Norfolk Boreas Offshore Wind Farm Applicant's Comments on Deadline 13 Submissions

Applicant: Norfolk Boreas Limited
Document Reference: ExA.ASR.D14.V1
Deadline 14

Date: August 2020
Revision: Version 1
Author: Royal HaskoningDHV

CAWSTON HIGH STREET - INTERVENTION SCHEME  
Scale 1:500

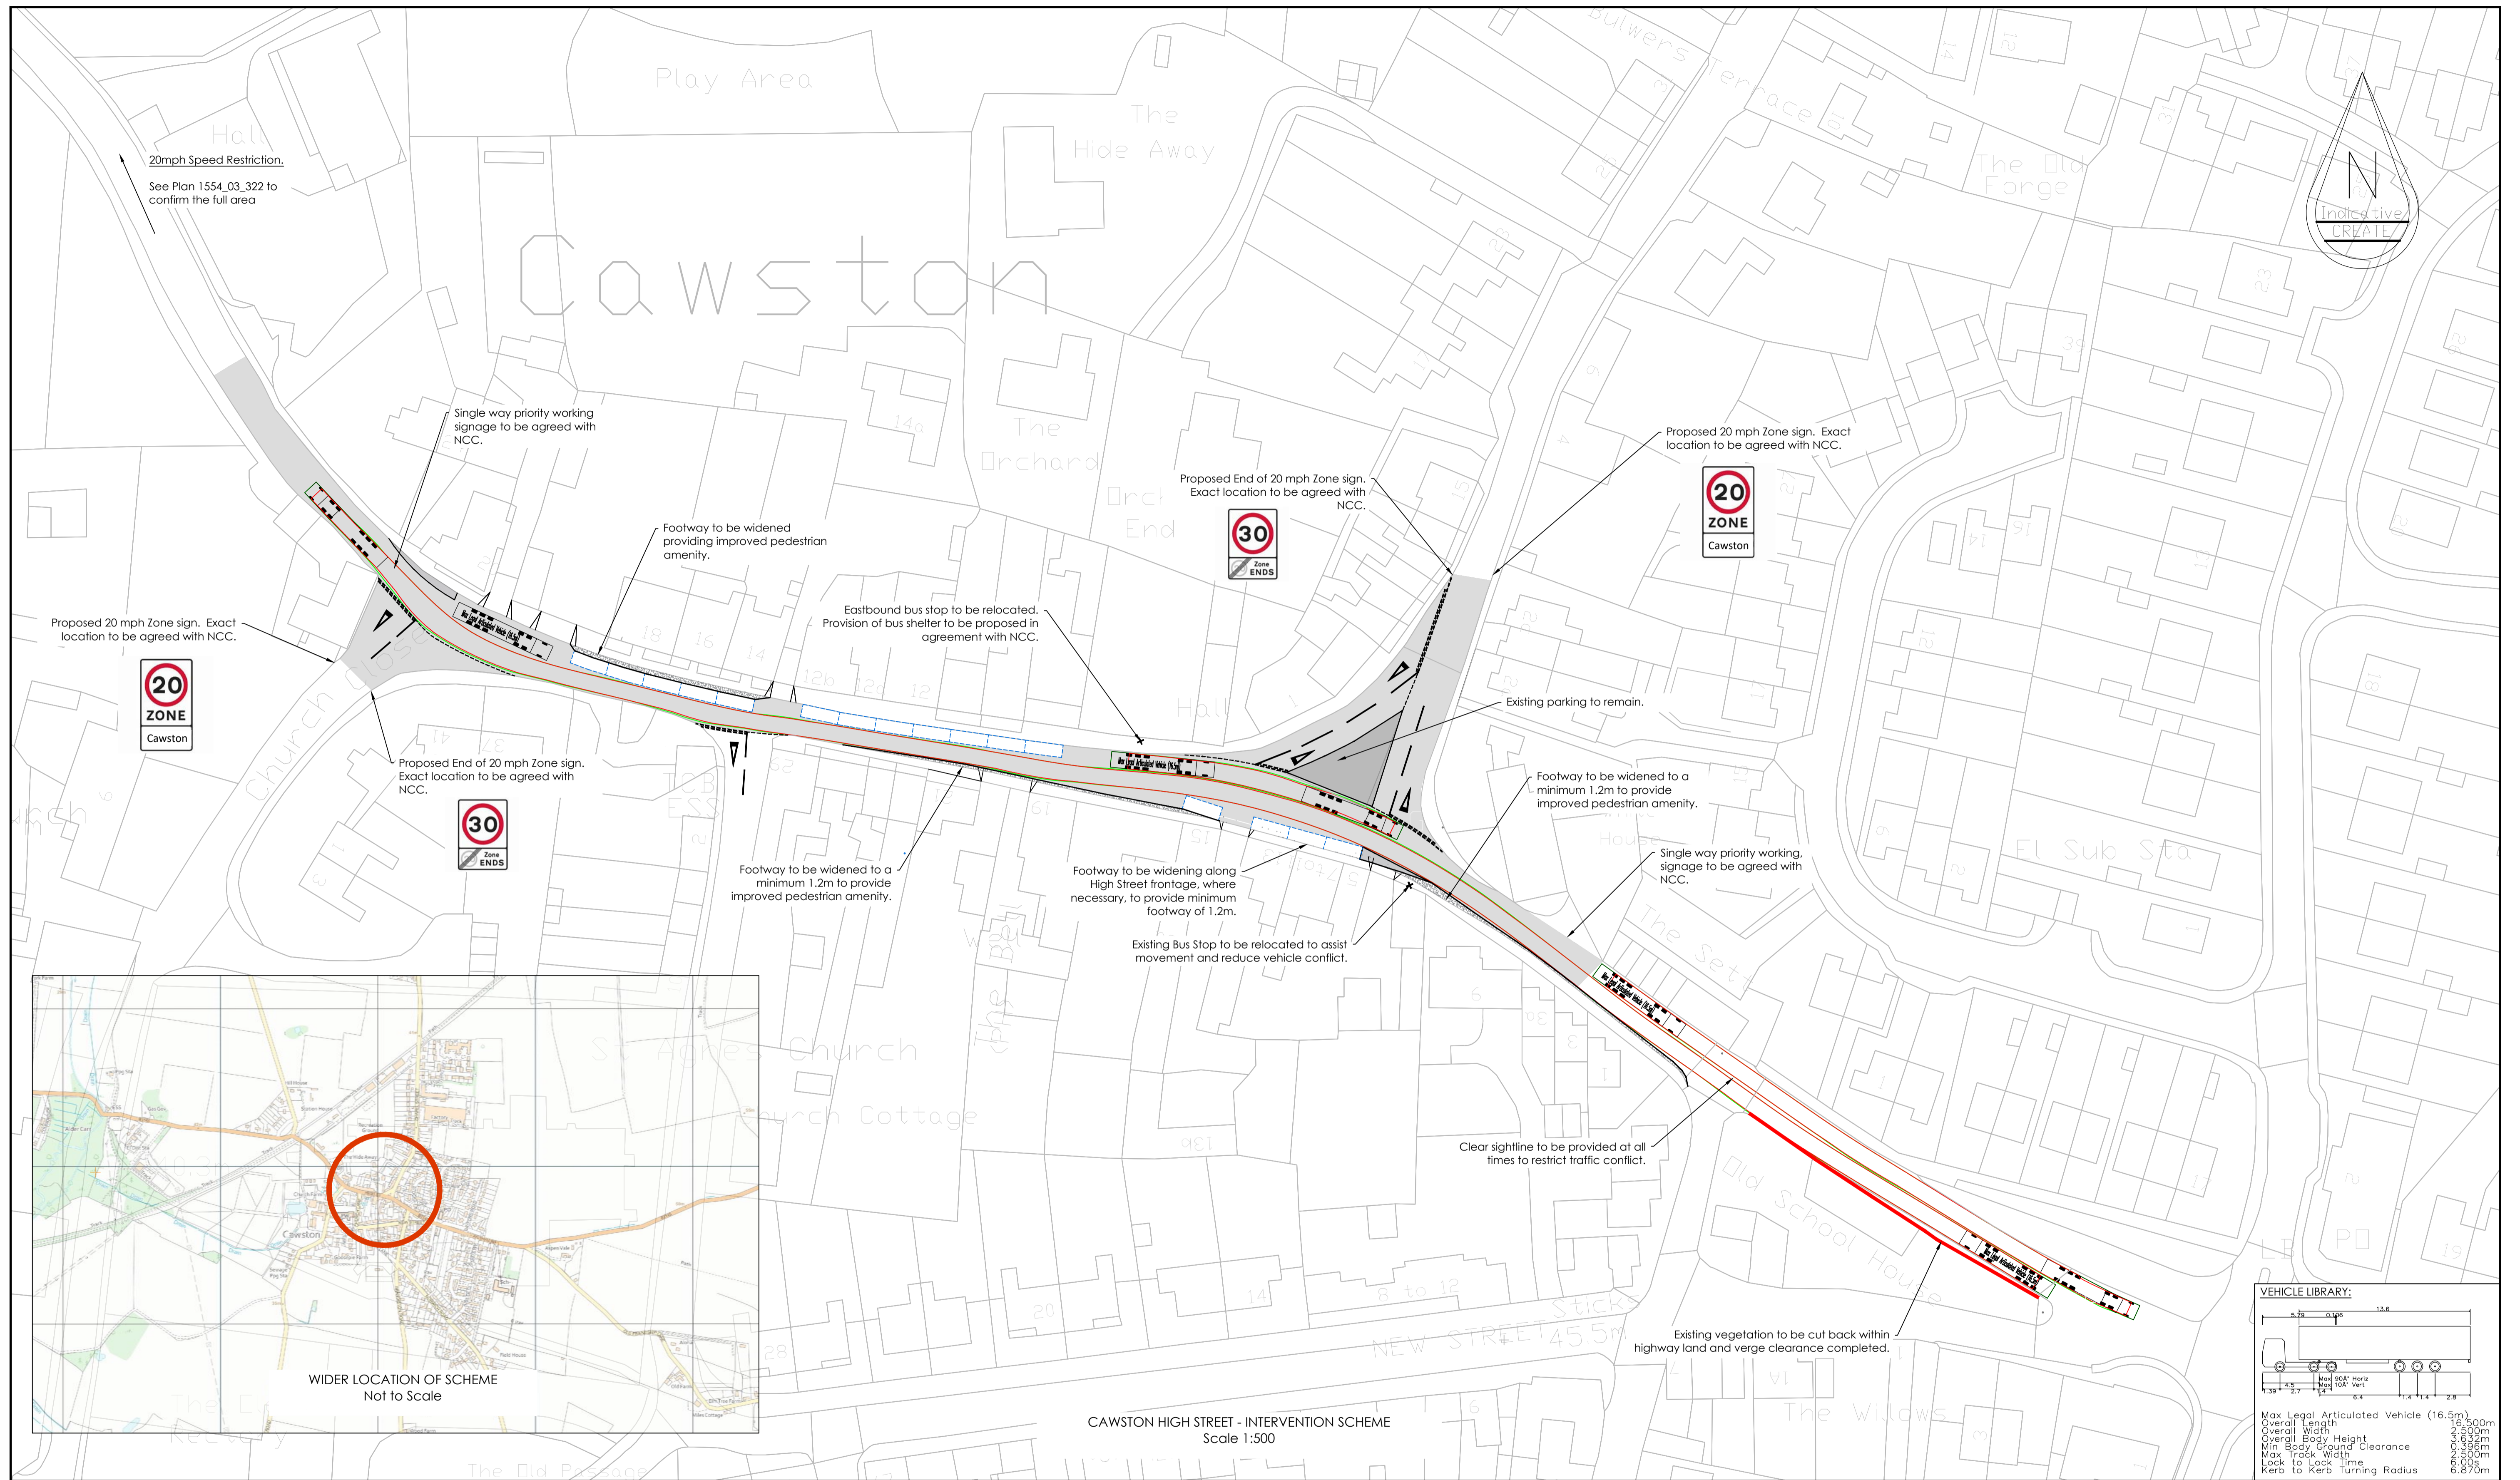
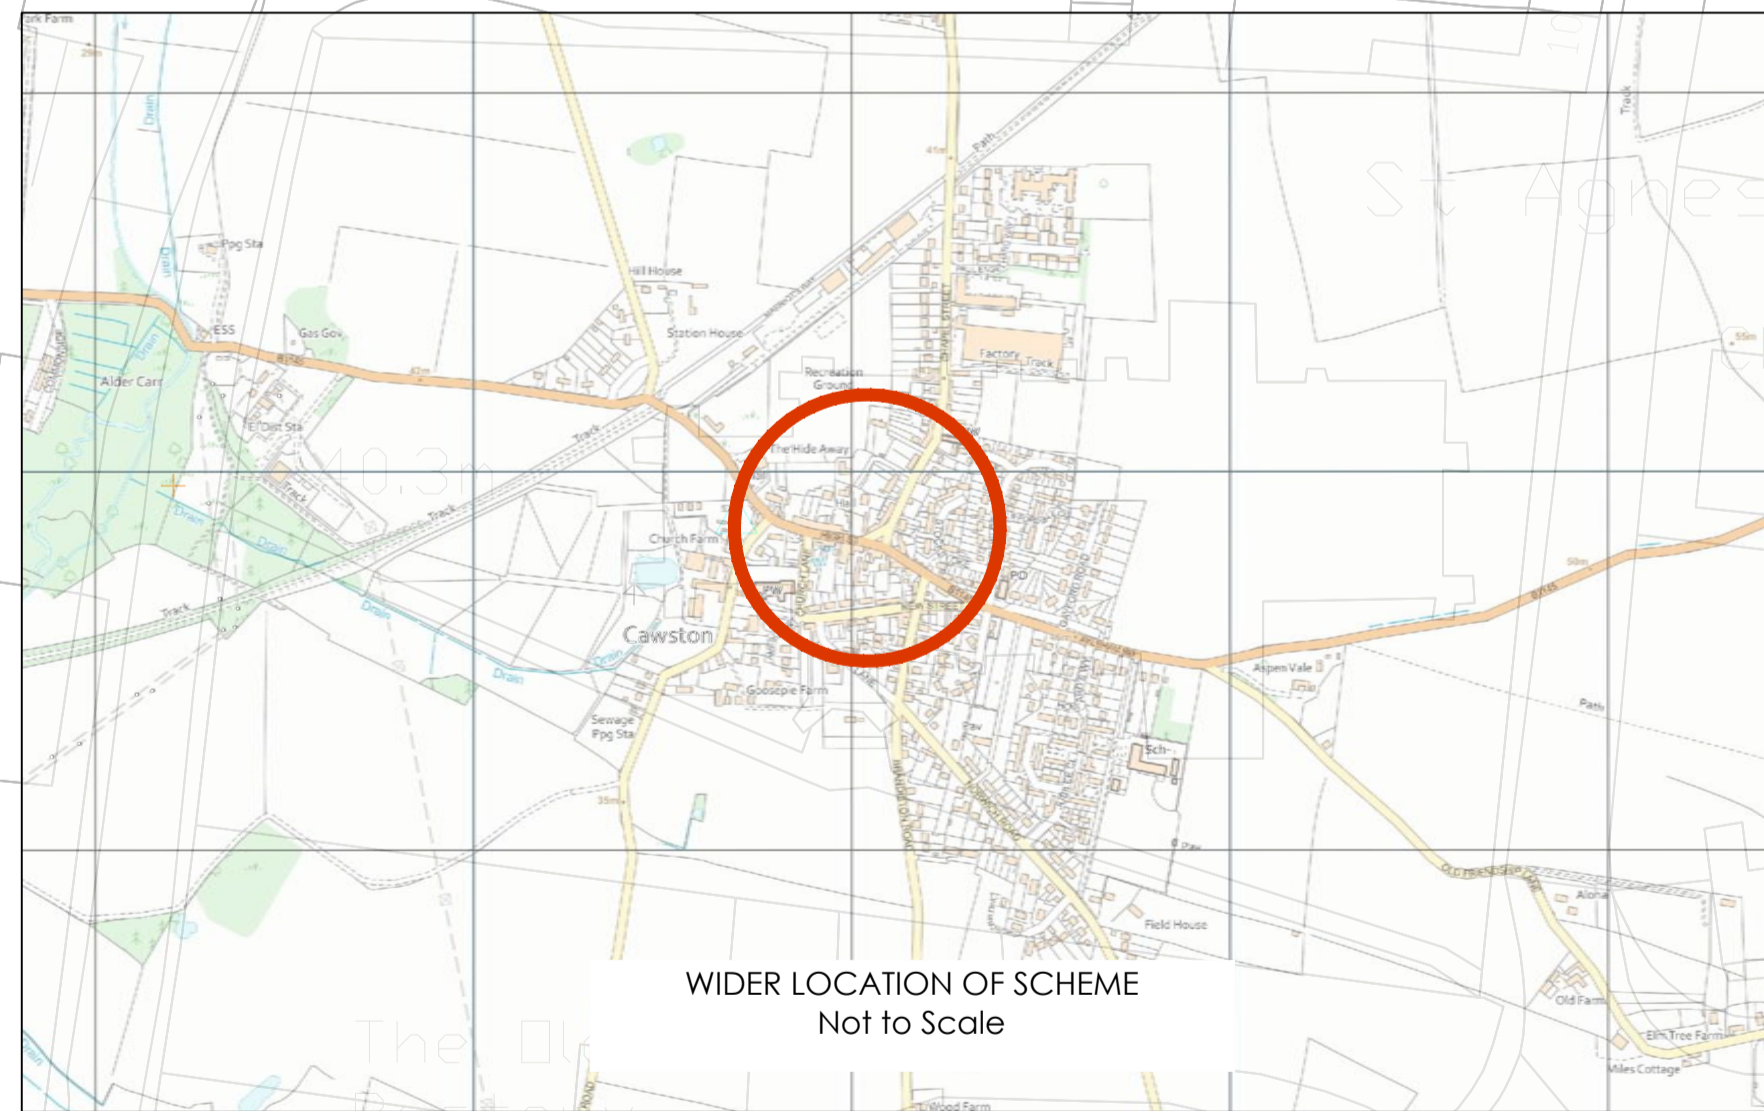
<p>Inadequate Road Space</p> <p>CPC continue to raise concerns over wingmirrors, including that the Applicant has suggested that the additional width of mirror is an additional 80mm and CPC suggest 350mm is more representative. They also makes reference to width of light vehicles/vans (source Google) and suggest there is inadequate provision for such vehicles with wing mirrors within a 5.0m wide road space.</p>	<p>At the meeting held on the 21st July 2020 with CPC [please refer to REP13-019] the Applicant reconfirmed the position set out at Deadline 10 that the maximum dimensions are a 2.55m HGV with a 250mm maximum projection of the wing mirror from the body or trailer, and this is the widest projection permitted under EU/UK legislation and that this is what has been included in the swept path analysis. The Applicant acknowledged that a wing mirror itself could be measured at 350mm, due to the tapering of the cab but the projection from the body can only be 250mm in accordance with legislation. Therefore, the maximum vehicle width would be 3.05m.</p> <p>The same legislation requires the wing mirrors to be adjustable from the driver's seat in the event that an obstruction is encountered. It is stressed that the Applicant views this as a contingency rather than a basis for the HIS design.</p> <p>There is a short section of the scheme in the vicinity of No.10 High Street that narrows to just over 5m wide after which the carriageway alignment flares out to an average of ~</p>

Summary of Submission	Applicant's Comments
	<p>5.6m wide. A private car in the UK measures in the range of 1.7m (compact hatch back) to 1.9m (large SUV). The HIS parking bays are sized similar to those applied to resident parking schemes and define a 2m wide box to encourage efficient use of road-space.</p> <p>The CPC figures quoted are for a large SUV with both wing mirrors fully extended. The parking bays are sized to encourage parking close to the kerbline (a behaviour that can be observed in current conditions) thus negating the influence of the wing mirror on the HGV path.</p> <p>In addition to horizontal dimensions, it is also important to understand the three-dimensional space that wing mirrors occupy. A HGV wing mirror is designed for a 2m eye height and a car at just over a metre. This means that the wing mirrors do not occupy the same space, and this effectively provides a further buffer zone between HGVs and parked vehicles. This concept can be observed on a daily basis as the background HGVs and Buses traverse through the High Street.</p> <p>Available road space was at the forefront of the independent road safety recommendations all of which have been addressed by the finalised HIS [detailed in the Revised HIS Road Safety Decision Log REP5-055]. It is therefore reiterated that the scheme meets the design principle of providing adequate road space for HGVs to traverse the High Street without the requirement to mount or project over the pavement.</p>
